Recommendation Report for Planning Permission for Works or Extension to a Dwelling

REF NO: AW/275/18/HH

LOCATION: 229 Manor Way
Aldwick
PO21 4HT

PROPOSAL: First floor side extension, loft conversion with rear dormer, rear canopy, and extension to detached garage. This application affects the character and appearance of Aldwick Bay Conservation Area

SECTION A-A

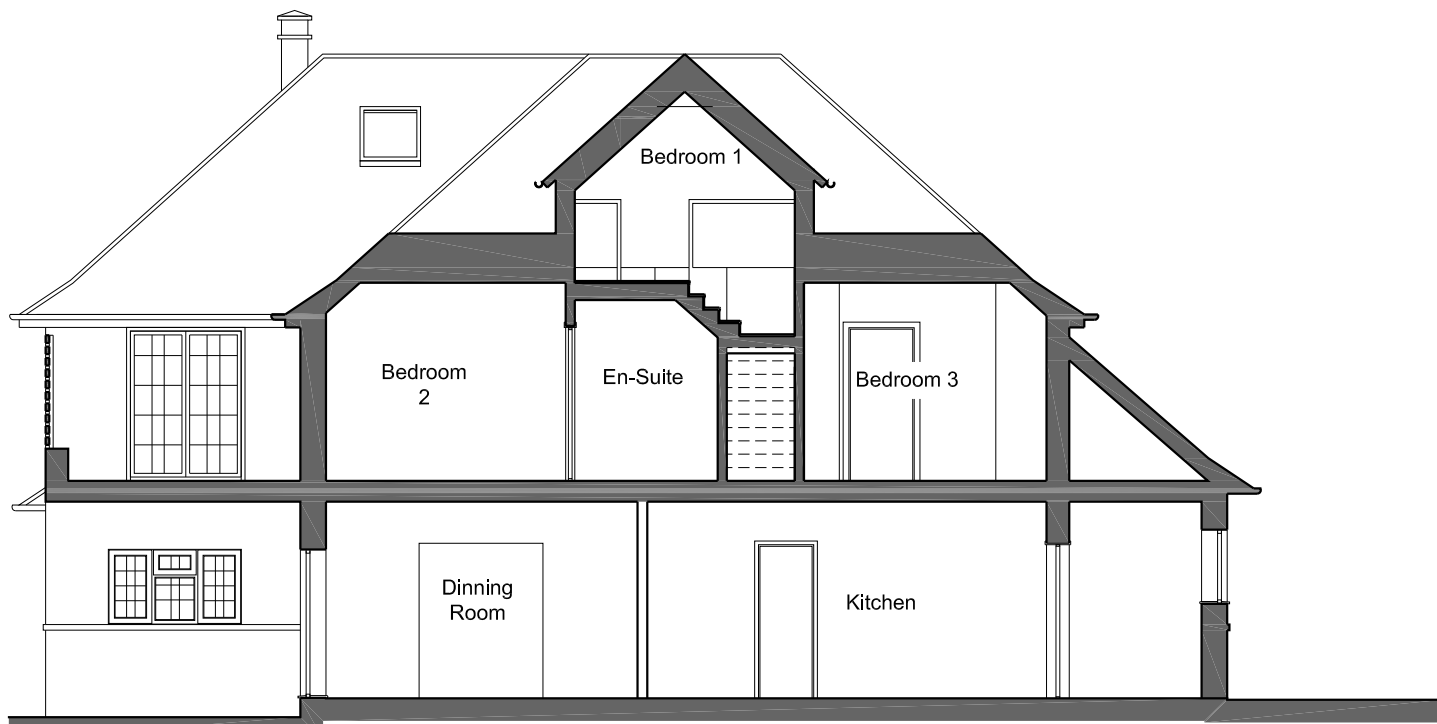
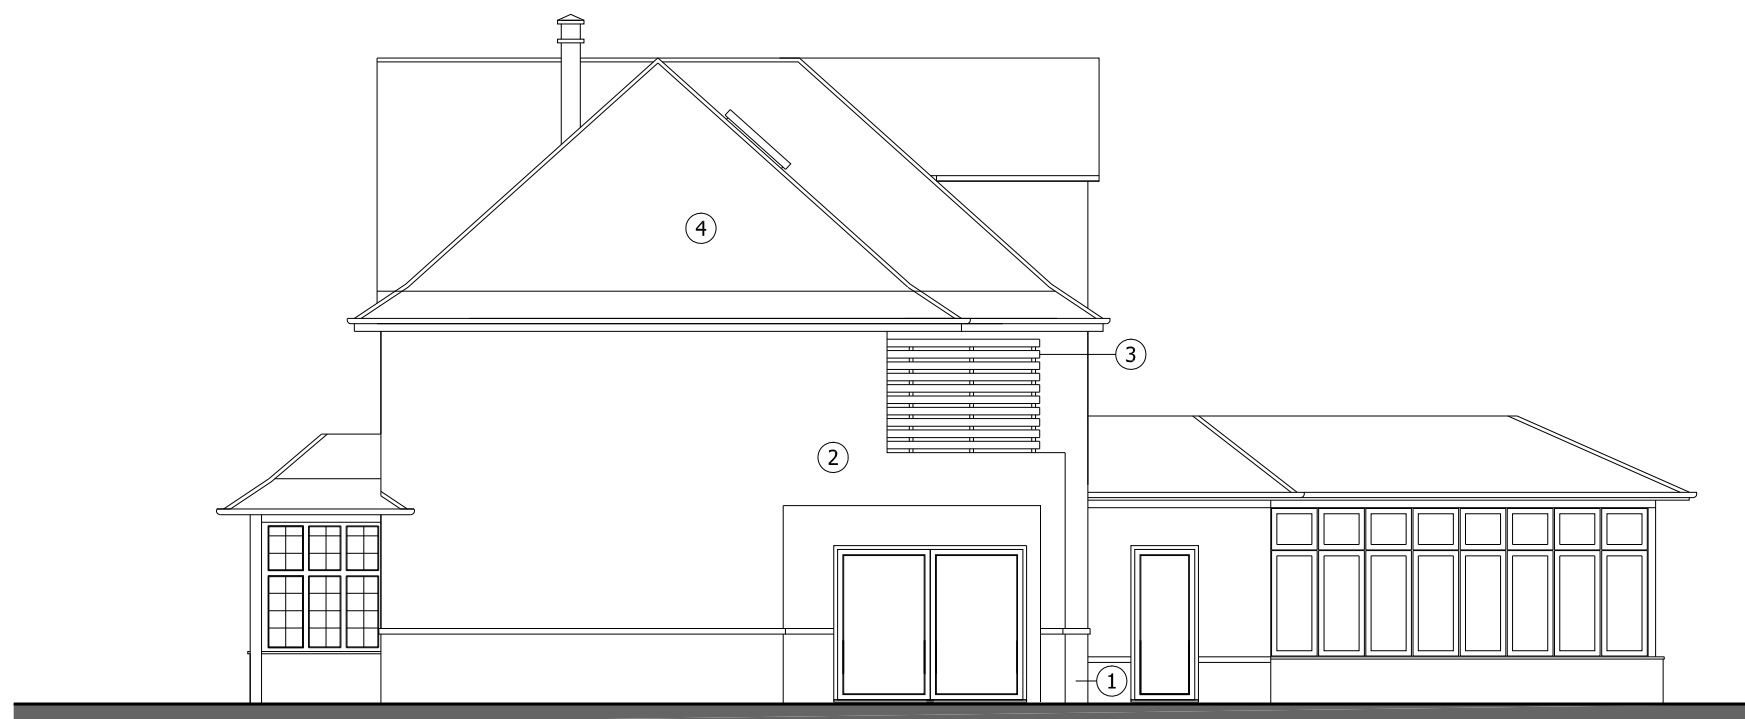
The proposed first floor side extension will be located to the south eastern elevation. The extension will increase its depth 3.7m to the rear of the dwelling although will not extend beyond the rear elevation of the property. The extension will provide a first floor balcony with a covered area below and will have a hipped roof to match the ridge height of the host dwelling. The proposed balcony will have screening to restrict any potential overlooking upon the property to the south east. Due to the shape of the boundary there will be a separation distance of 1.1m to the south east and due to its siting and the boundary treatment in place is not considered to give rise to significant overshadowing or overbearing upon the neighbours at this elevation.

The proposal also involves a conversion of the loft space to create an additional bedroom and bathroom and as a result a rear dormer will be constructed. It is relatively large with a depth of 4m extending from the ridge line of the host dwelling. It will have a height of 3m and a width of 3.4m with a gable roof. However, the window serves a staircase/landing area and therefore any overlooking is not considered to be significant. Also due to the siting of the dwelling to the north west which is set around 13m behind that of the host dwelling, it is not likely to give rise to any adverse overlooking at this elevation or to the rear where there is 30m separation to the boundary.

- 4 The balcony screening shall be constructed as shown on the approved drawing 103 to the

north east and south east elevation to a height of 1.7m and retained in its entirety in perpetuity. The balcony shall also not be used until the balcony guarding is completed.

Scale: 1:100	Drawn: V. BOTEZAT	Checked: R. Stefonski	Approved:	Date: 26.07.2018
Job No: 1352	Drawing No: 104	Revision:

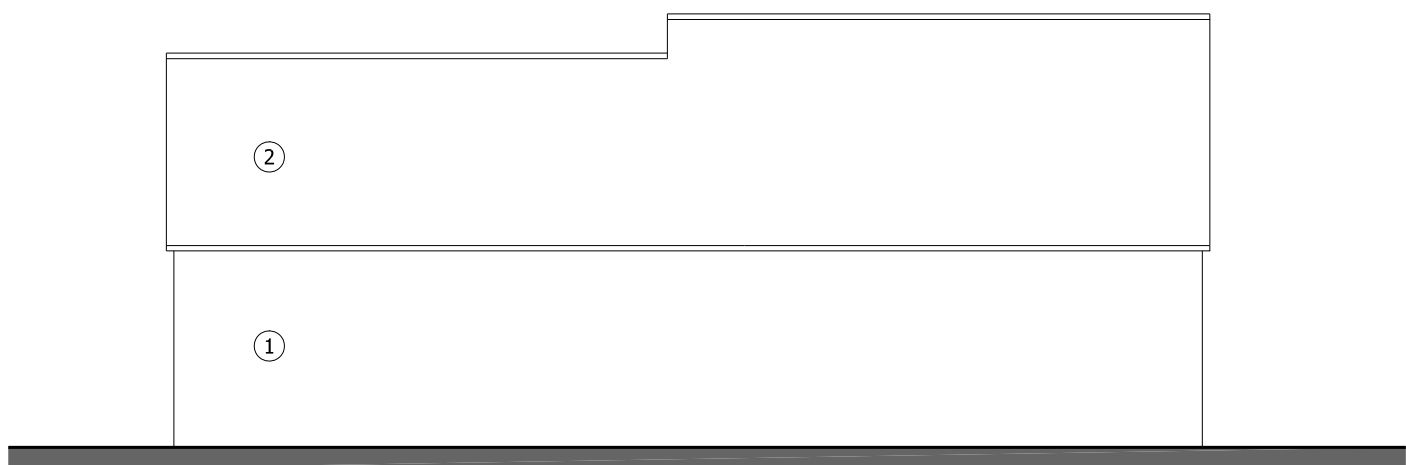
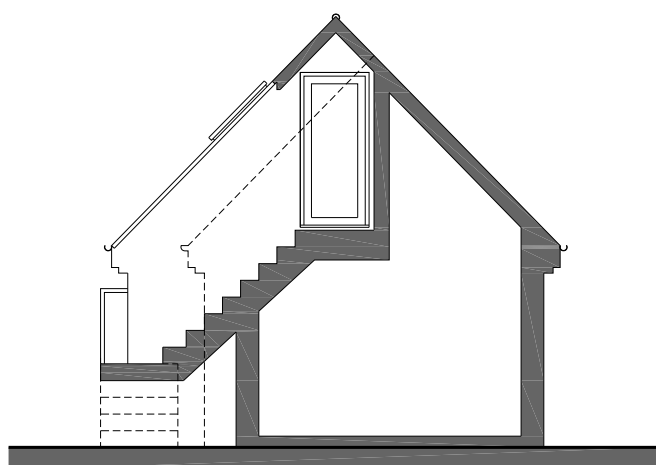
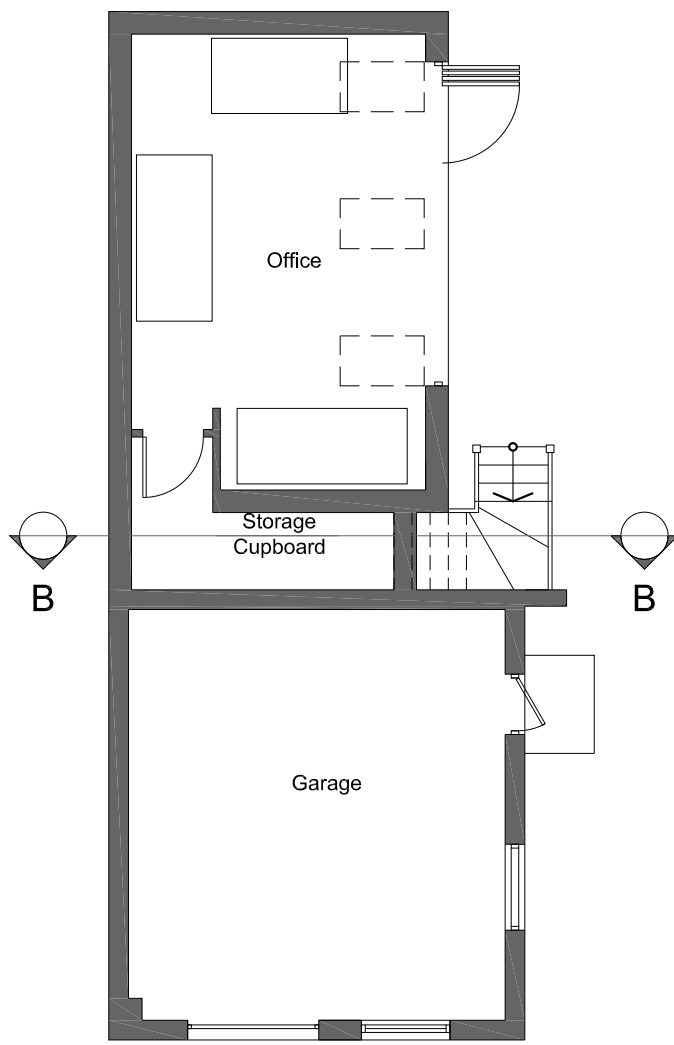
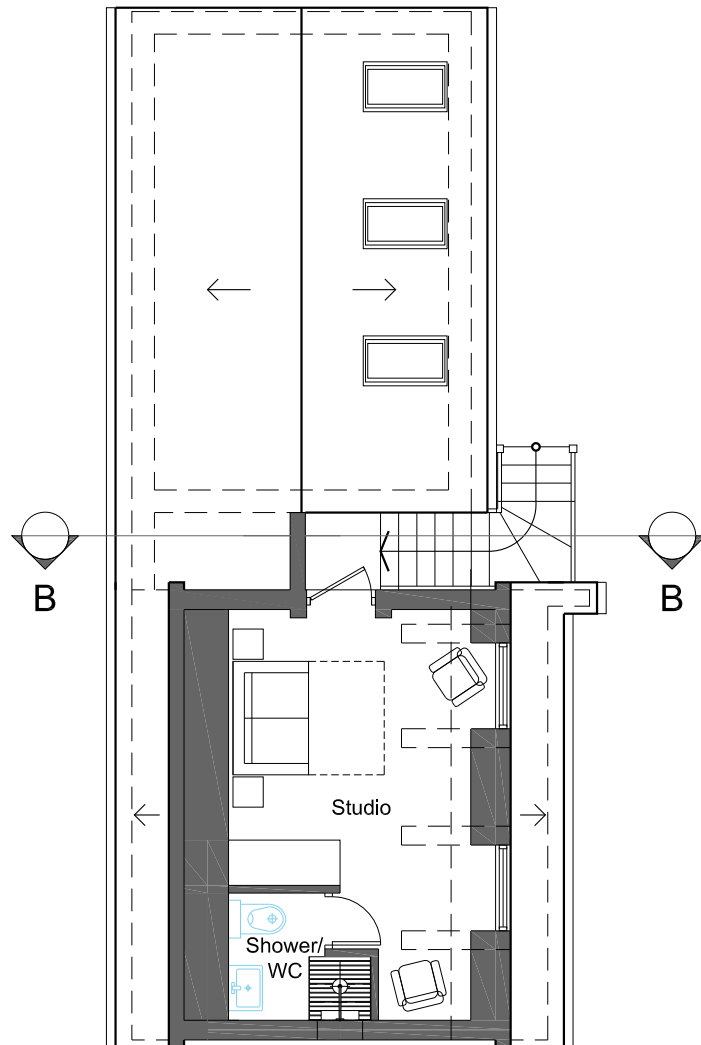
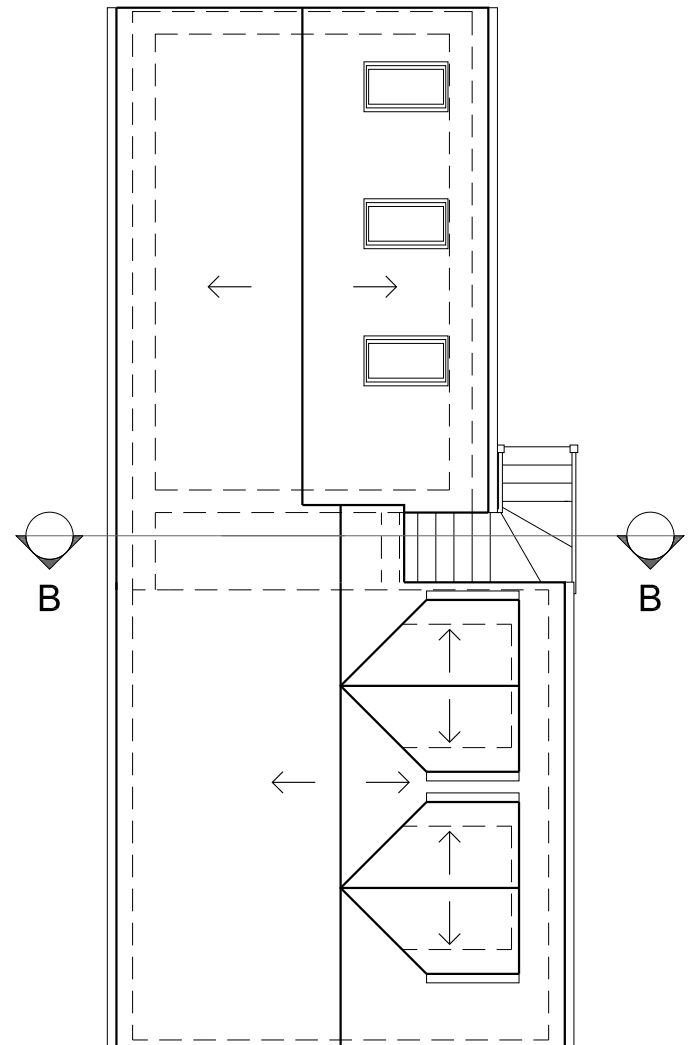
There is currently a detached two storey garage with a length of approx. 7m. with an external staircase to the north west. This will be extended a further 6.5m along the north western boundary. It has a height of 5.1m which is just below that of the existing garage. The proposed extension will be sited along the north western boundary and therefore whilst it will be close to the neighbouring property it is not considered to appear overbearing or overshadowing upon this elevation. This is due to the siting of the neighbouring dwelling around 8m behind that of the front elevation of the existing garage. The proposal therefore only extends around 4.5m past the side elevation of the neighbouring property, which serves a two storey garage also. Again due to its siting, the separation from the boundary to the neighbouring property increases to the rear of the garage from 1m to 3.5m. Whilst it is large in height and depth as a result of the siting of the extension and neighbouring property it is not considered to give rise to an overbearing or overshadowing impact upon this elevation. With 13m to the rear and with sufficient planting, the development is also not considered overbearing upon this elevation.

2 dormers will be installed to the existing garage which will face south east. However with around 15m to the south eastern boundary and substantial planting, it is not considered overlooking will be significant. The extended part of the garage will have a void area to the first floor and therefore whilst there will be 3 velux windows installed due to its height above finished floor level these are not considered to give rise to any overlooking. No windows are Due to the scale of the garage a condition will be included to restrict its use to prevent it being used as a single unit of accommodation in the future.
